City of Portland, Maine - Building or Use Permit Application

Permit No: 05-0092	Issue Date: FEB 25 2005	CBL: 117 E021001
-----------------------	-----------------------------------	---------------------

Proposed Project Description:
Addition to existing home
** Rear deck NOT included*

Dept: Zoning **Status:** Approved with Conditions **Reviewer:** Tammy Munson **Approval Date:** 02/25/2005

TYPICAL FDN WALL

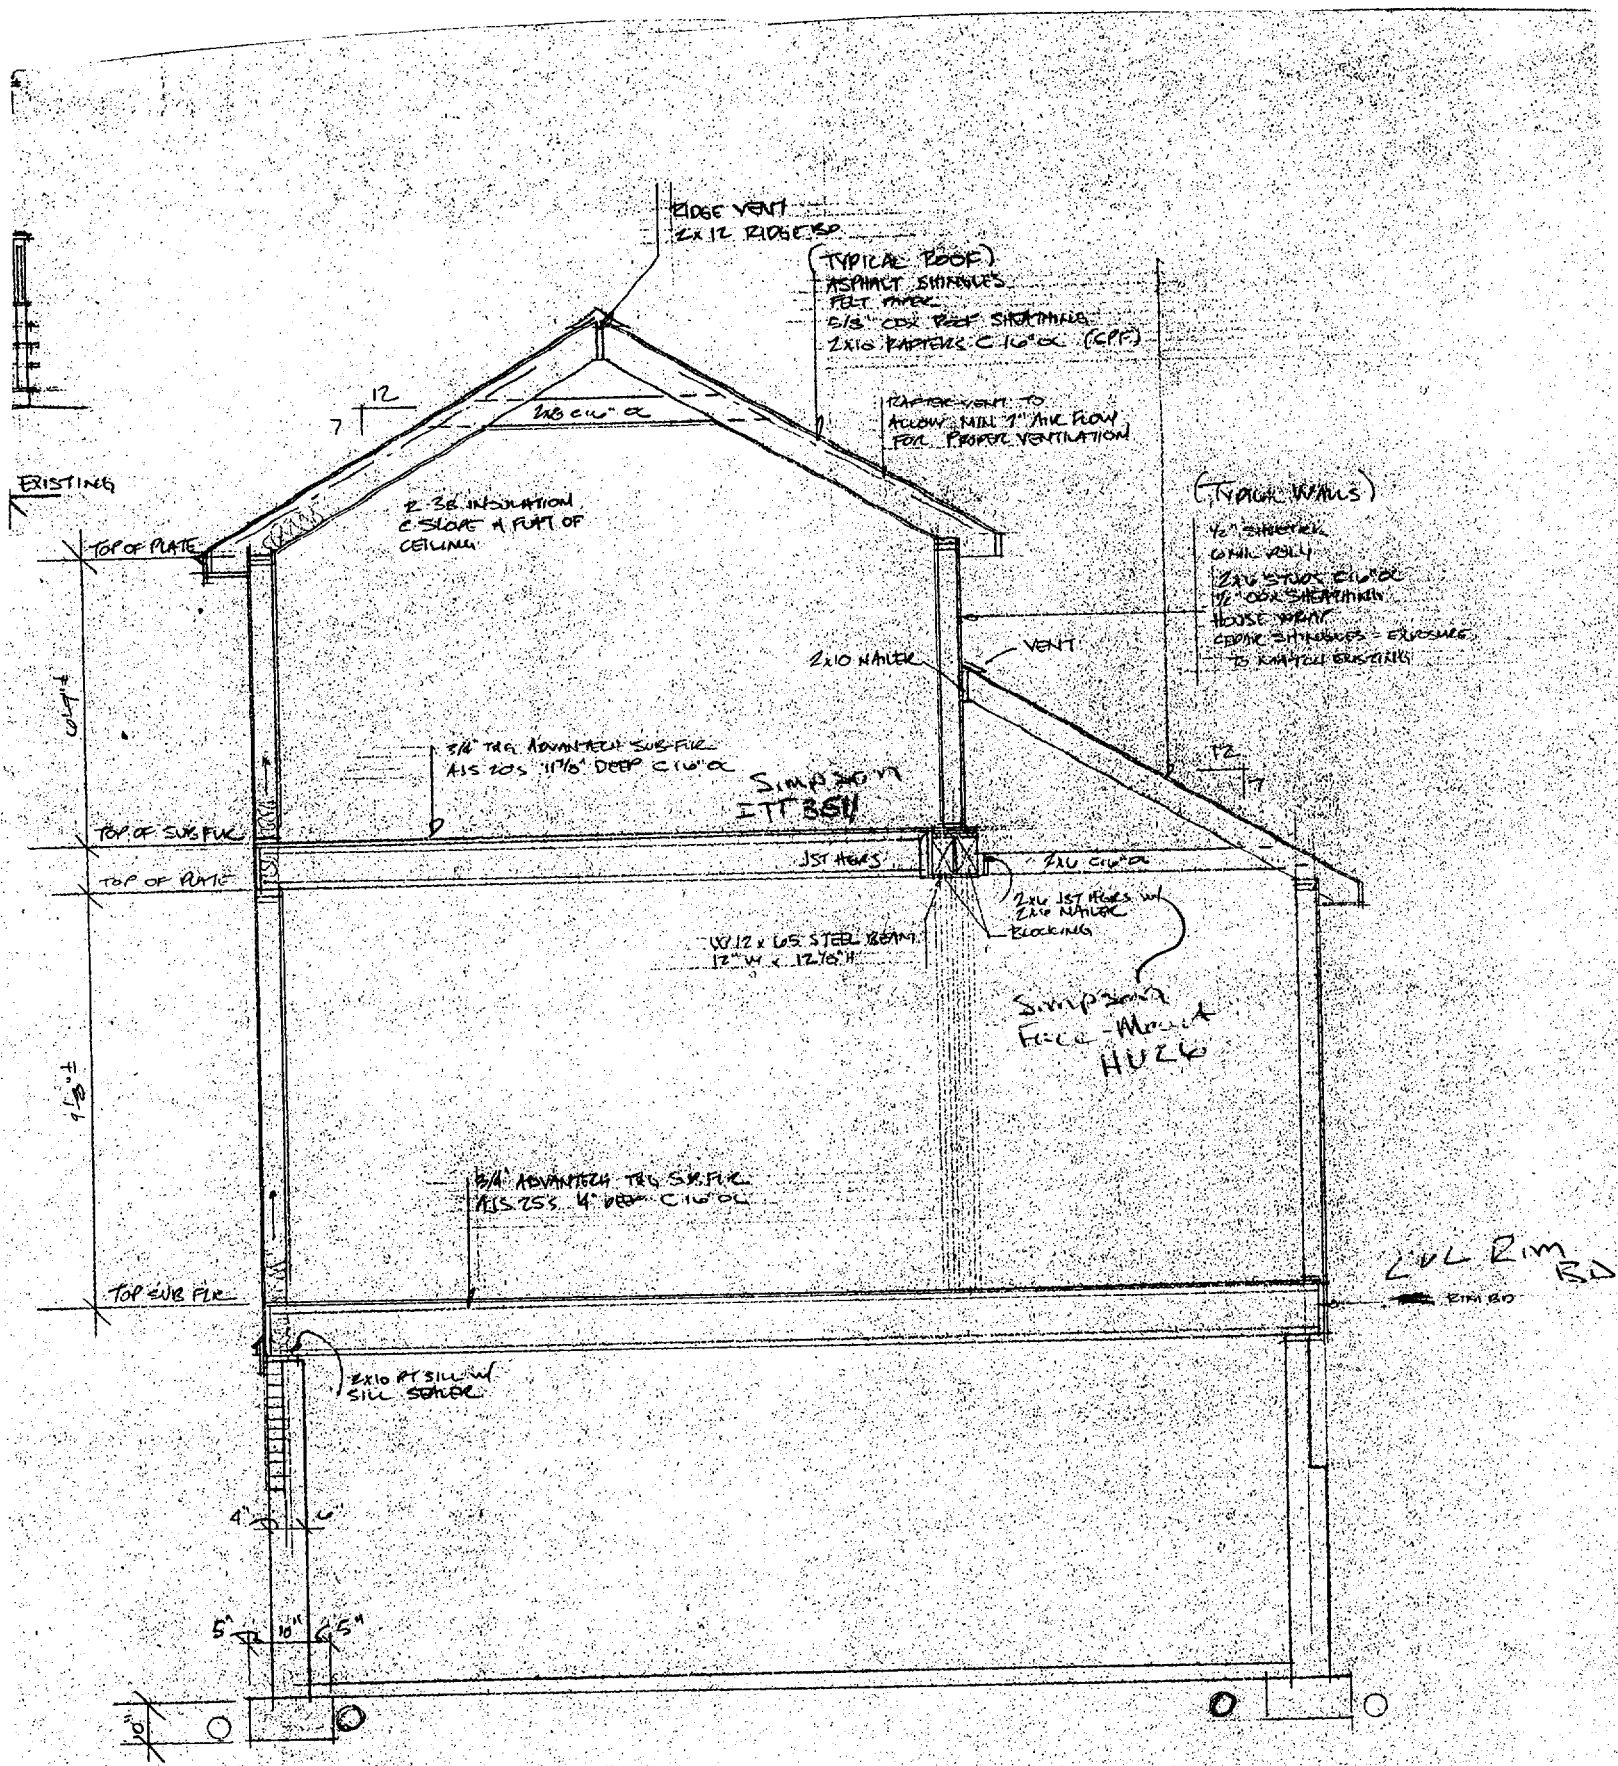
1/27/05-tmm: Needsetbacks shown on plot plan, header schedule, attachment of foundation, access to basement, design of all beams, egress windows, smokes, stair details, deck framing, - called builder and he will address.

2/25/05-tmm: met w/builder - went over all req. - ok to issue.
